Application no: H16-0839-11

Description: Proposed signage

Location: Rear of Bentleys Restaurant
Off Swan Street
Spalding
Lincs

Amendment: Design of timber edging (dwg. no. 2317-04B)

Drawing No.
04

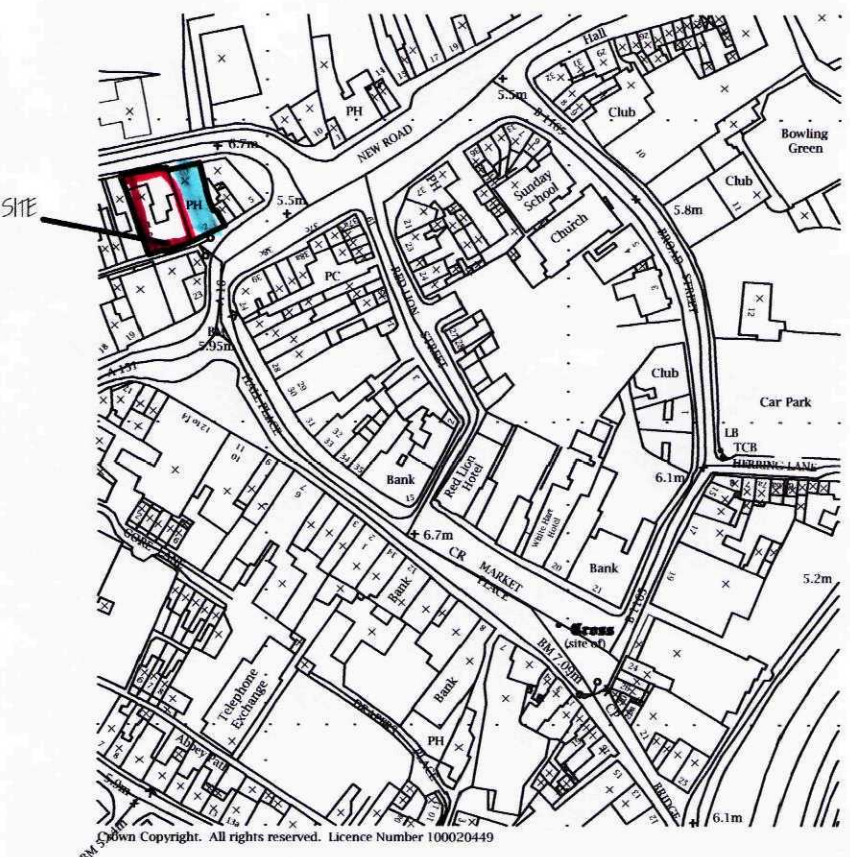
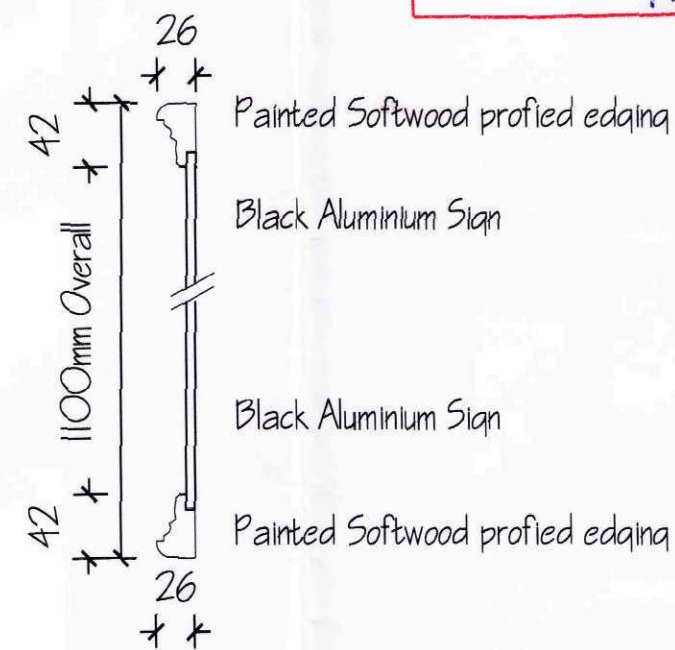
Further to the above referenced application, the submitted details are very basic. Please provide a sectional drawing showing the design of the timber edging mentioned on Dwg. No. 2317-04.

Following your email below and our recent telephone conversation on Wednesday please find attached a copy of the amended plan, as discussed. Just to confirm our client's are happy to use aluminium instead of plastic.
